<b>Application Ref:</b>	3/2021/0165	 <div>Ribble Valley Borough Council</div> <div><a href="http://www.ribblevalley.gov.uk">www.ribblevalley.gov.uk</a></div>	
<b>Date Inspected:</b>	15/3/2021		
<b>Officer:</b>	BT		
<b>DELEGATED ITEM FILE REPORT:</b>		<b>Decision</b>	Approval

<b>Development Description:</b>	Dormer extension to front.
<b>Site Address/Location:</b>	23 Mayfair Crescent, Wilpshire, Blackburn. BB1 9PY

FRONT ELEVATION (SOUTH) PROPOSED

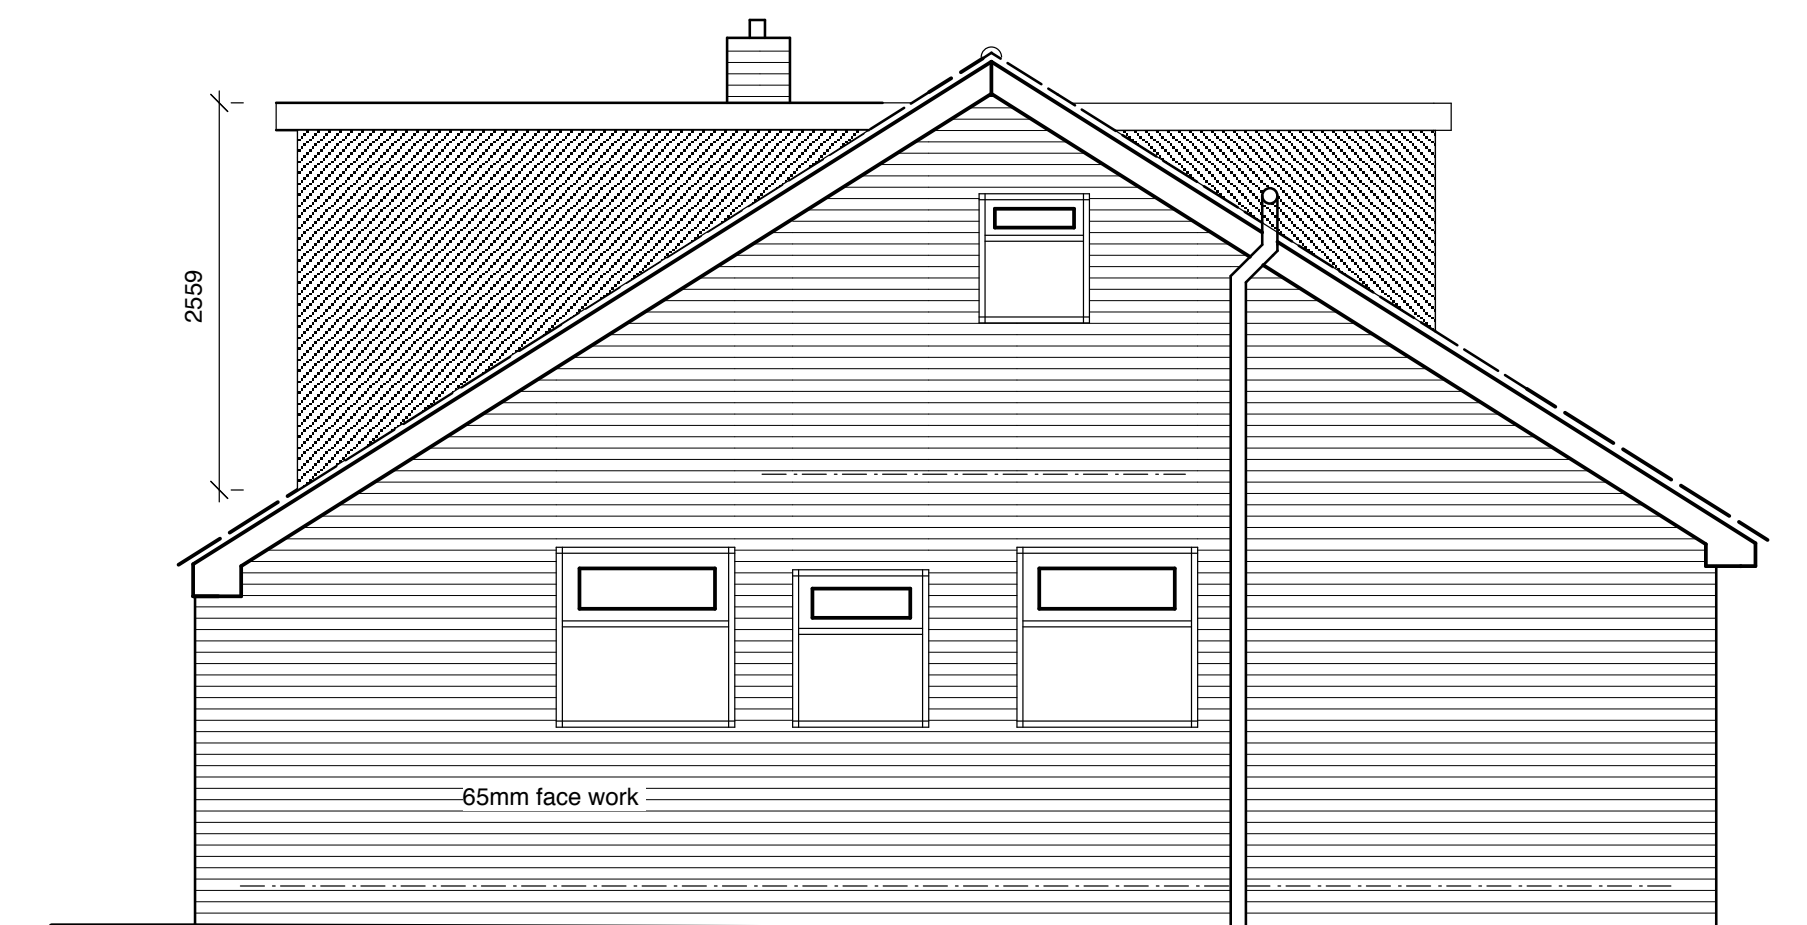
The front dormer extension will incorporate two casement windows on its Southern elevation which will allow views towards the front elevations of No. 22 and 24 Mayfair crescent. Both of these elevations contain windows forming part of habitable rooms however given that these windows are situated approximately 12 and 15 metres away respectively and off to the side of No. 23 Mayfair Crescent it is not considered that the proposal will lead to any significant loss of privacy through overlooking.

The front dormer extension will be South facing and as such any overshadowing effects will largely occur towards the rear of the main dwelling away from the neighbouring properties. Moreover, the front dormer will be set 850mm and 650mm back from the property's roof eaves and roof pitch respectively therefore it is not anticipated that the proposed works would have any adverse effects upon natural light or outlook for any neighbouring residents.

The front dormer extension will measure 6.4 x 4.2 metres with a height of 2.5 metres and will be visible within the public realm. As such, the proposal will have some visual impact however given that a total of 12 properties on Mayfair Crescent already contain front dormer extensions it is not considered that the proposal would be an incongruous addition to the existing street scene, nor is it considered that the proposed works would have a detrimental impact upon visual amenity.
